DRB Application No.: 10DRB-70095 Project # 1008137  
Project Name: Westgate Heights Subd.  
Agent: DSA Architects LLC Phone No.: 342-6200

**FILE: Project 1008137  
10EPC-40004 Amended Site Development Plan for Building Permit**

**RE: San Martin de Porres Parish – 8301 Camino San Martin SW**

This is a request for approval of an Amended Site Development Plan for Building Permit for the San Martin de Porres Parish expansion project. This Amended Site Development Plan was approved by the EPC on February 19, 2010 (1008137/10EPC-40004).

PRELIMINARY GRADING PLAN
1" = 30'

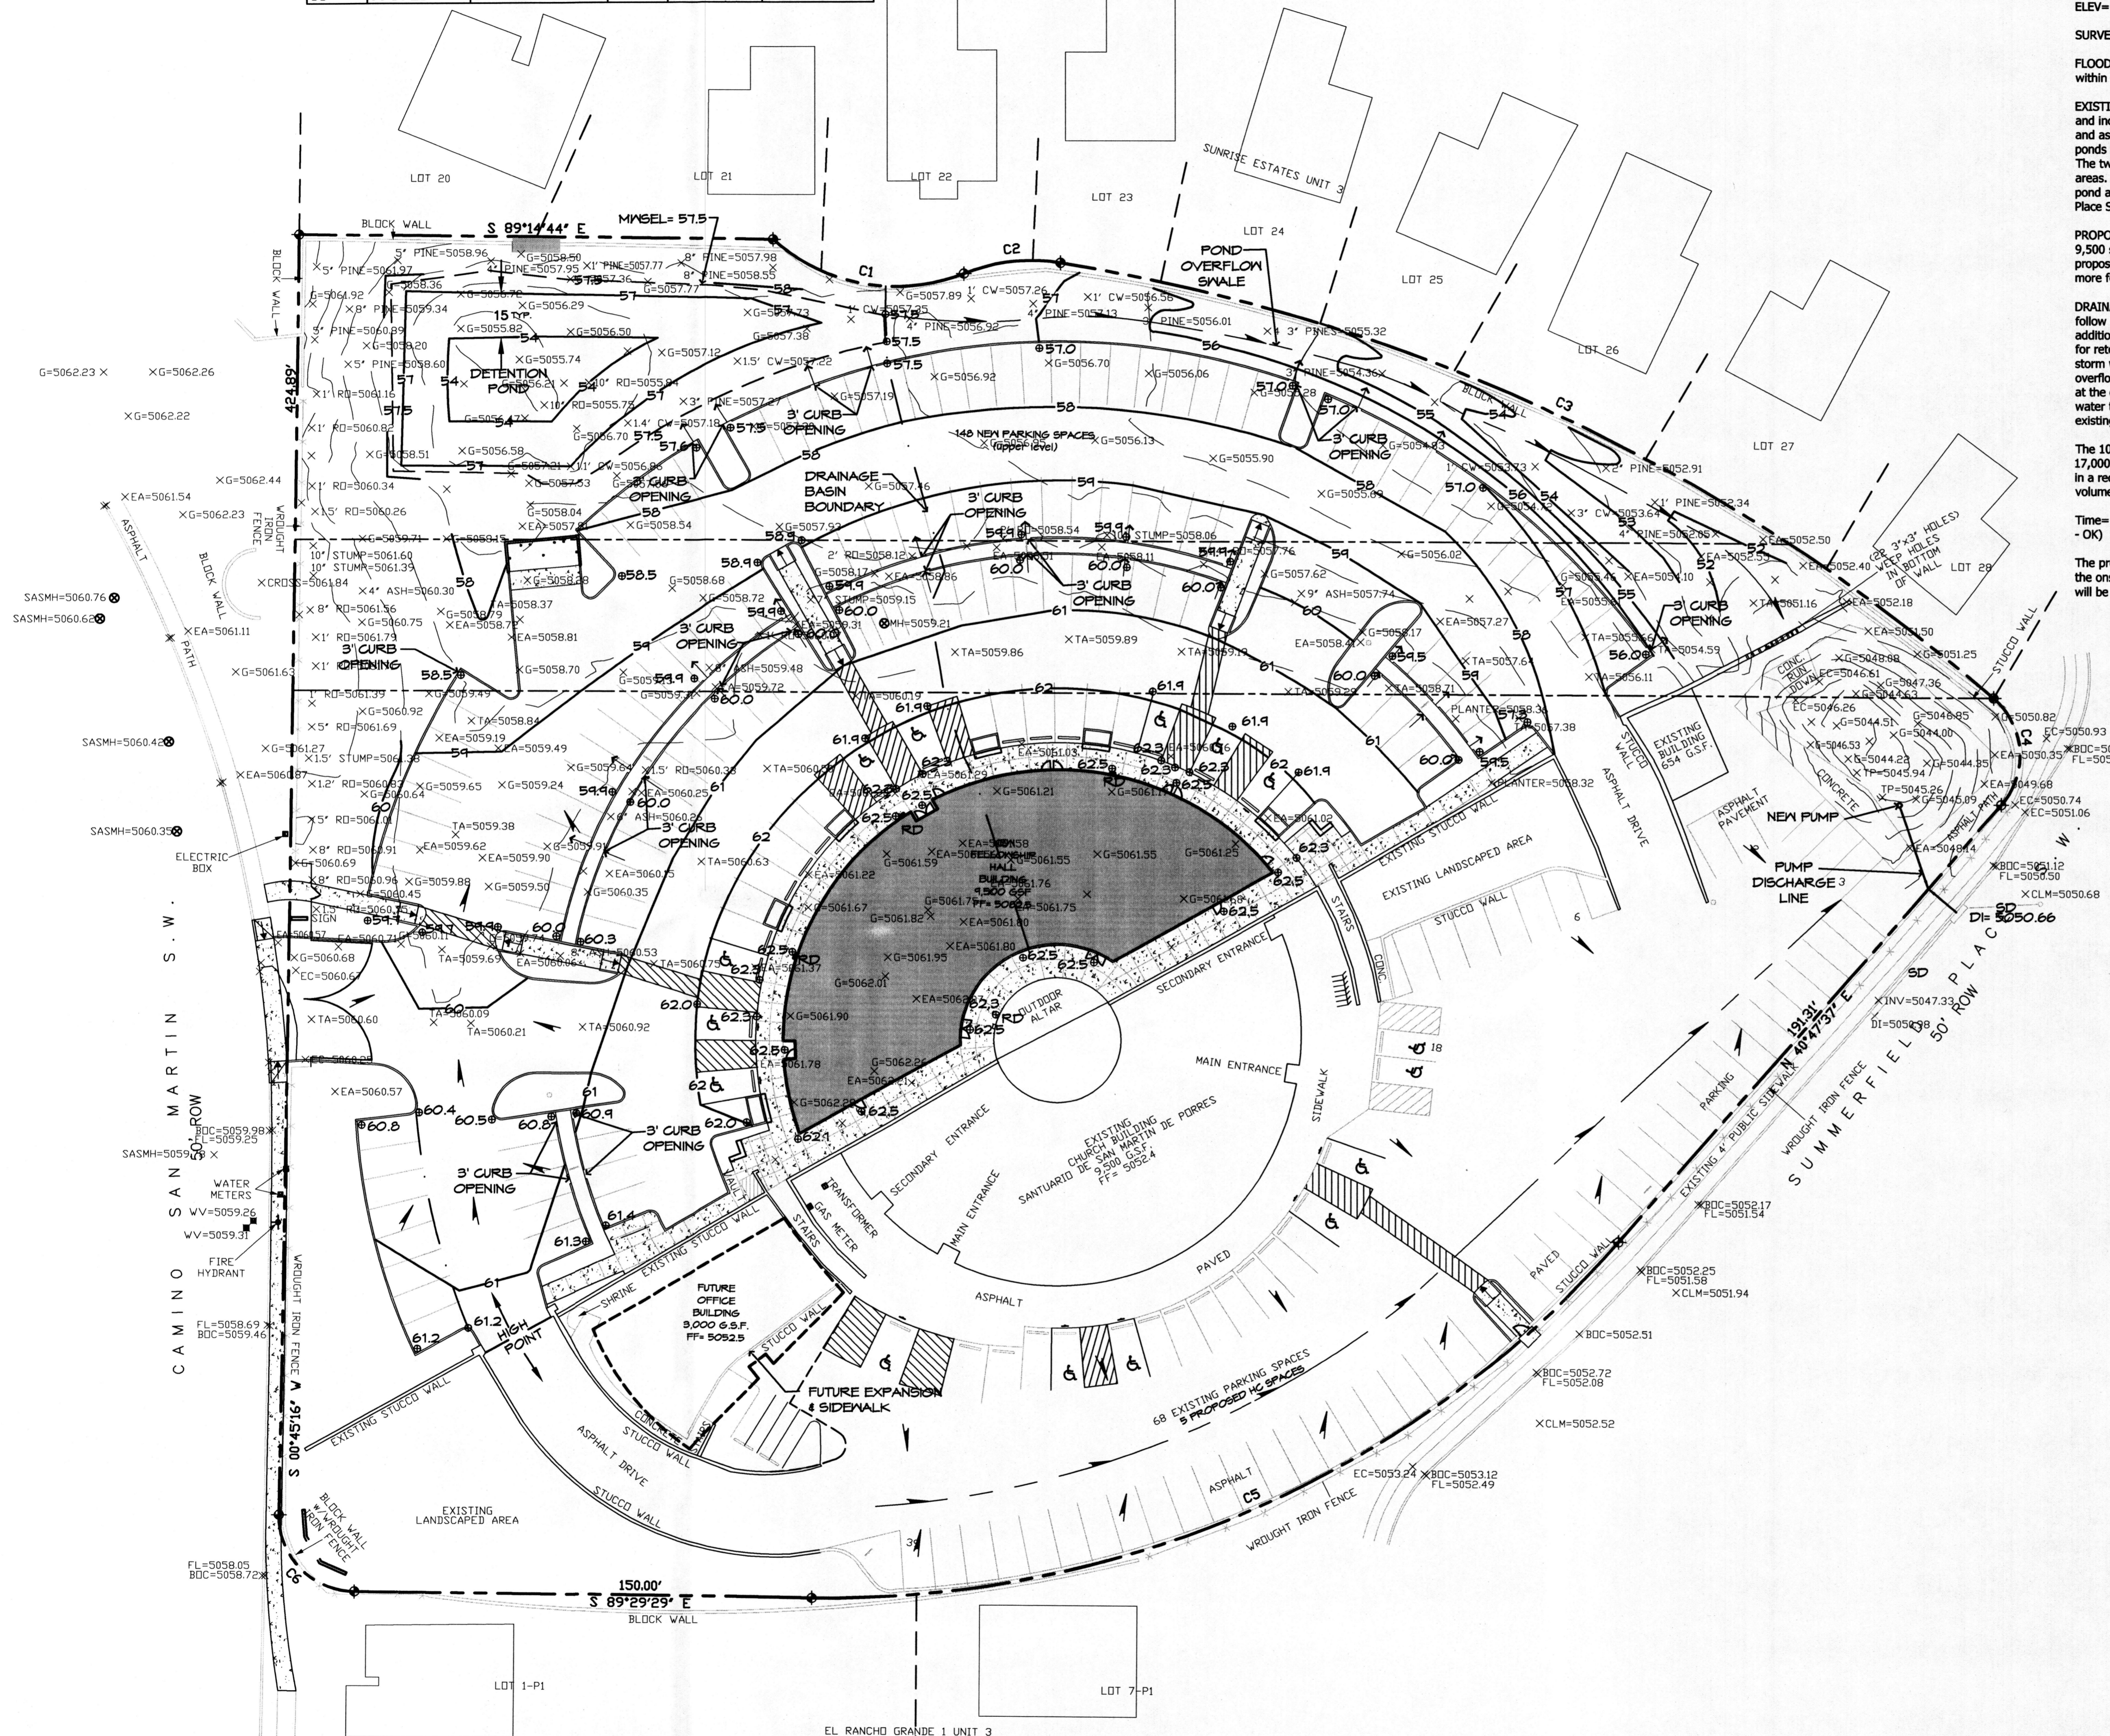
12. Grading & Drainage Plan

- a. Finished floor elevations have been added
- b. Preliminary drainage information for Phase II has been added.

1 BUILDING ELEVATION - NORTH
3/32" = 1'-0"

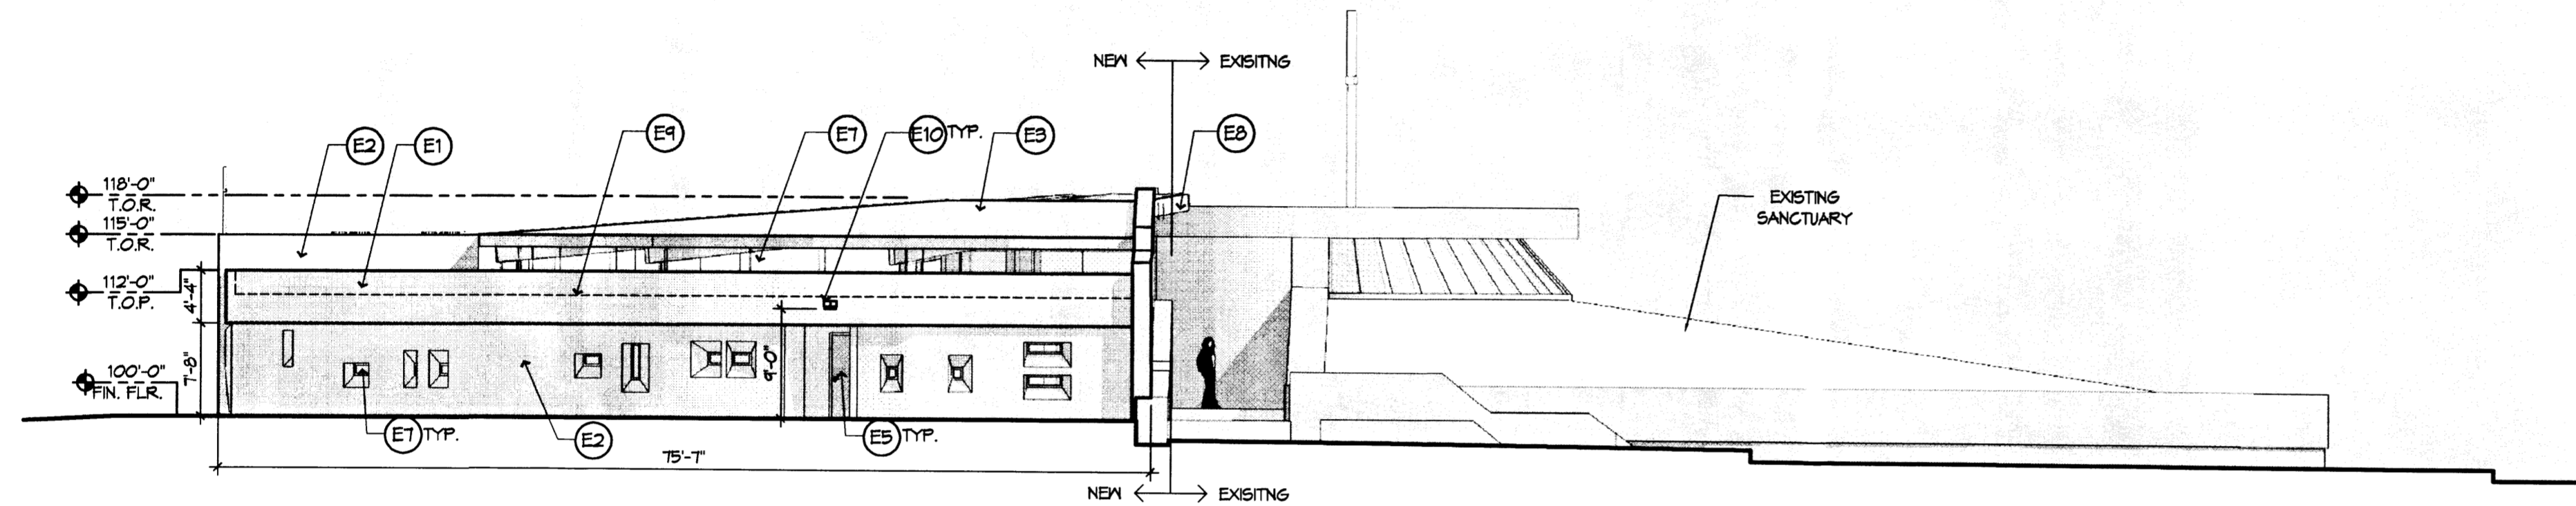
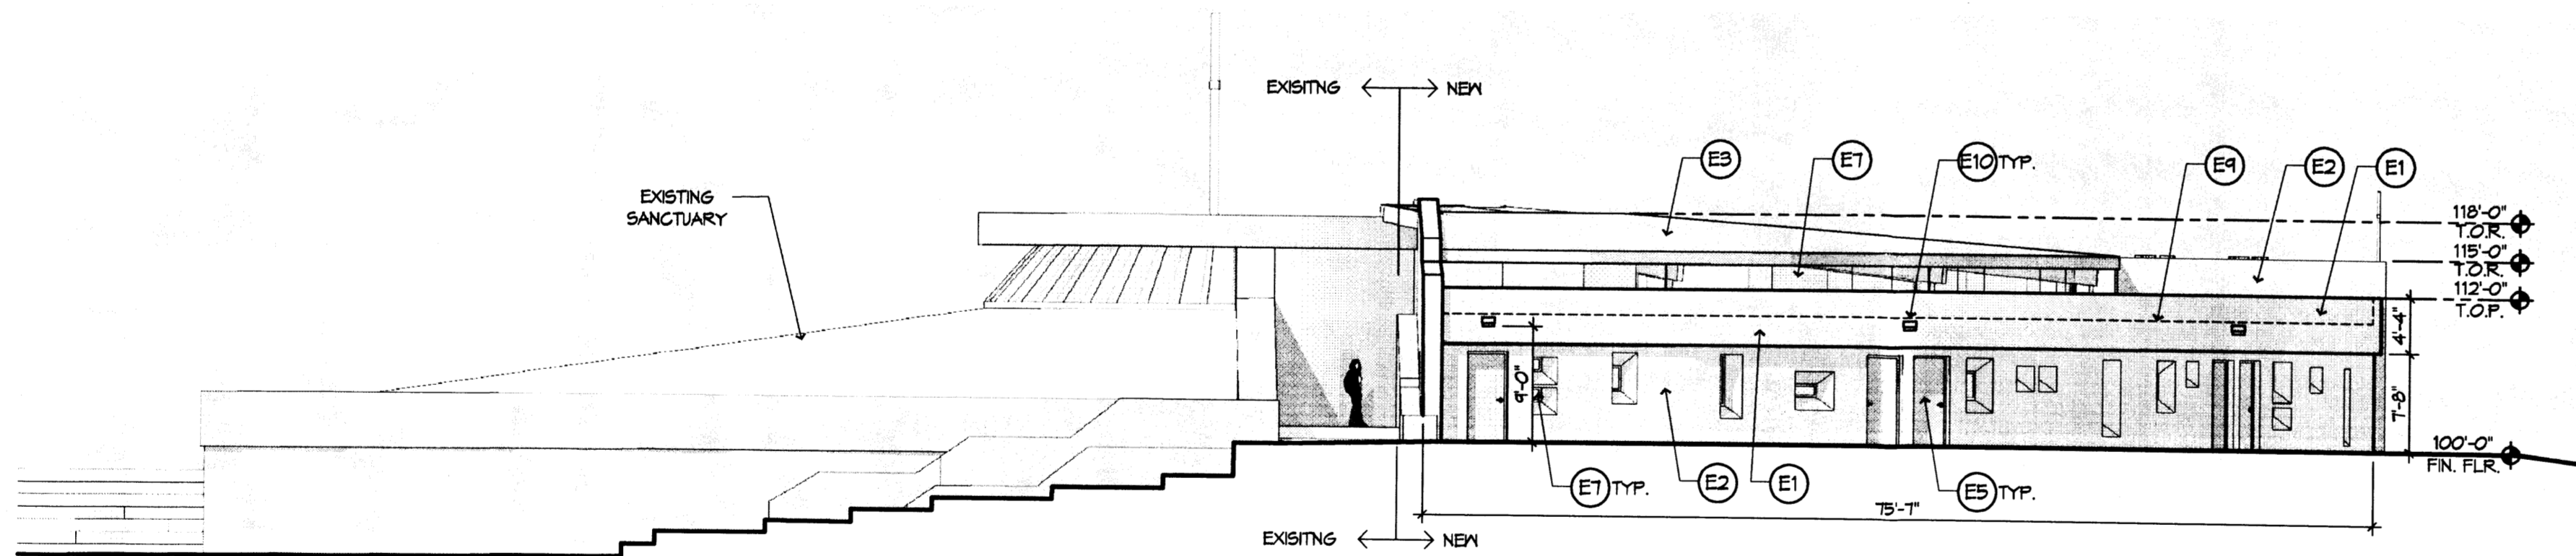
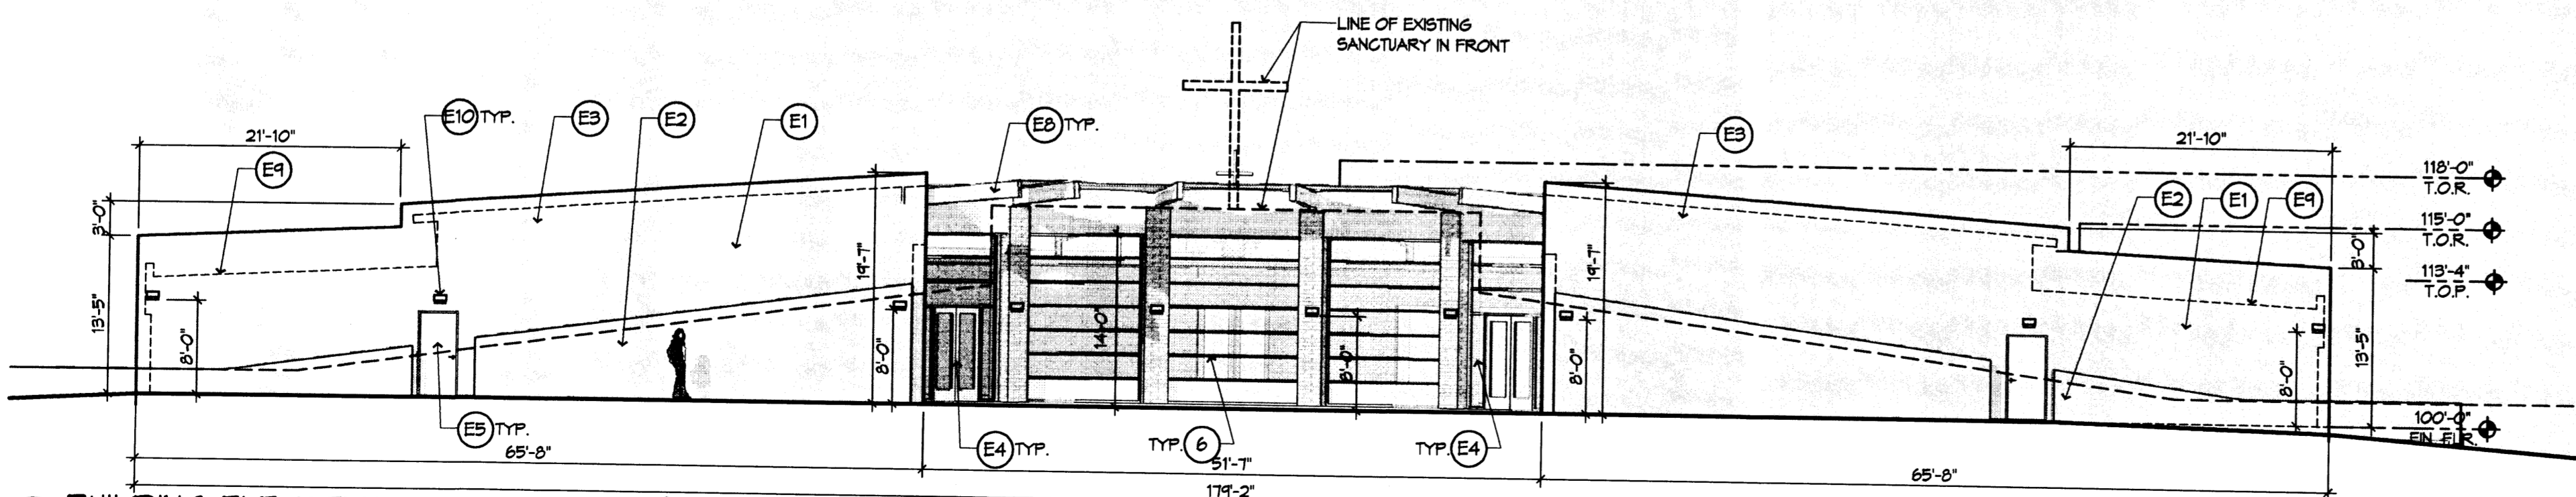
- d. Building mounted lighted has been added to sheet A-201.
9. Landscaping
- a. Existing landscaping on the north part of the site has been hatched.
  - b. Parking area tree calculations have been corrected.

13. Architecture: The metallic roof has been noted as low-reflective.
